Administrative Relief: Facts and Justification

Subject Property: 11275 FOREST EDGE DR COLORADO SPRINGS CO, 80908-3727 (Schedule Number: 6223000012)

Administrative Relief Request: PROPOSED (MAX) ENCROACHMENT INTO SIDE SETBACK OF 4'-10-5/8"± (19.5%±)

PAGE P1

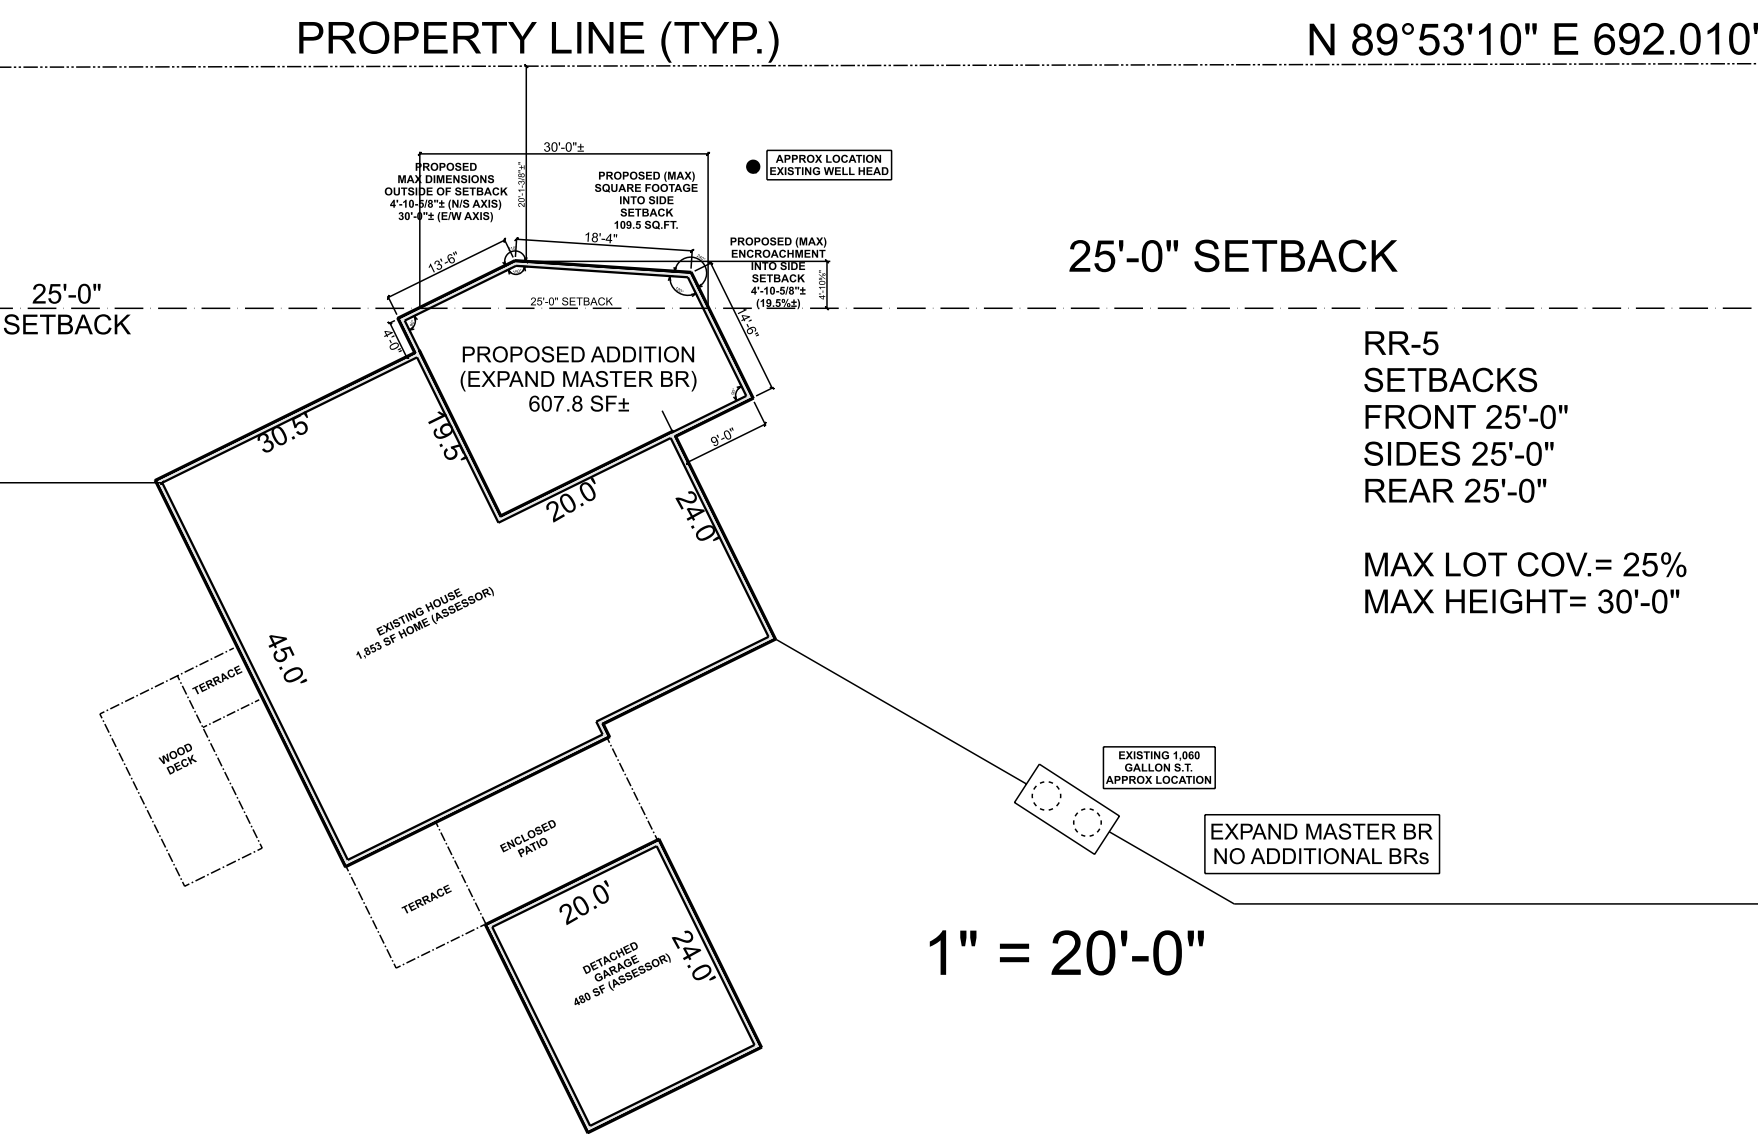
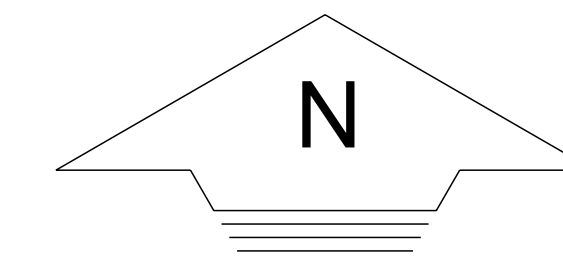
- Please add "PCD File No. ADR-22-002".
- Please add a statement confirming the proposed activity will not adversely impact adjacent properties or existing runoff patterns.
- Please add a statement confirming the proposed addition will not generate additional trips to the parcel.
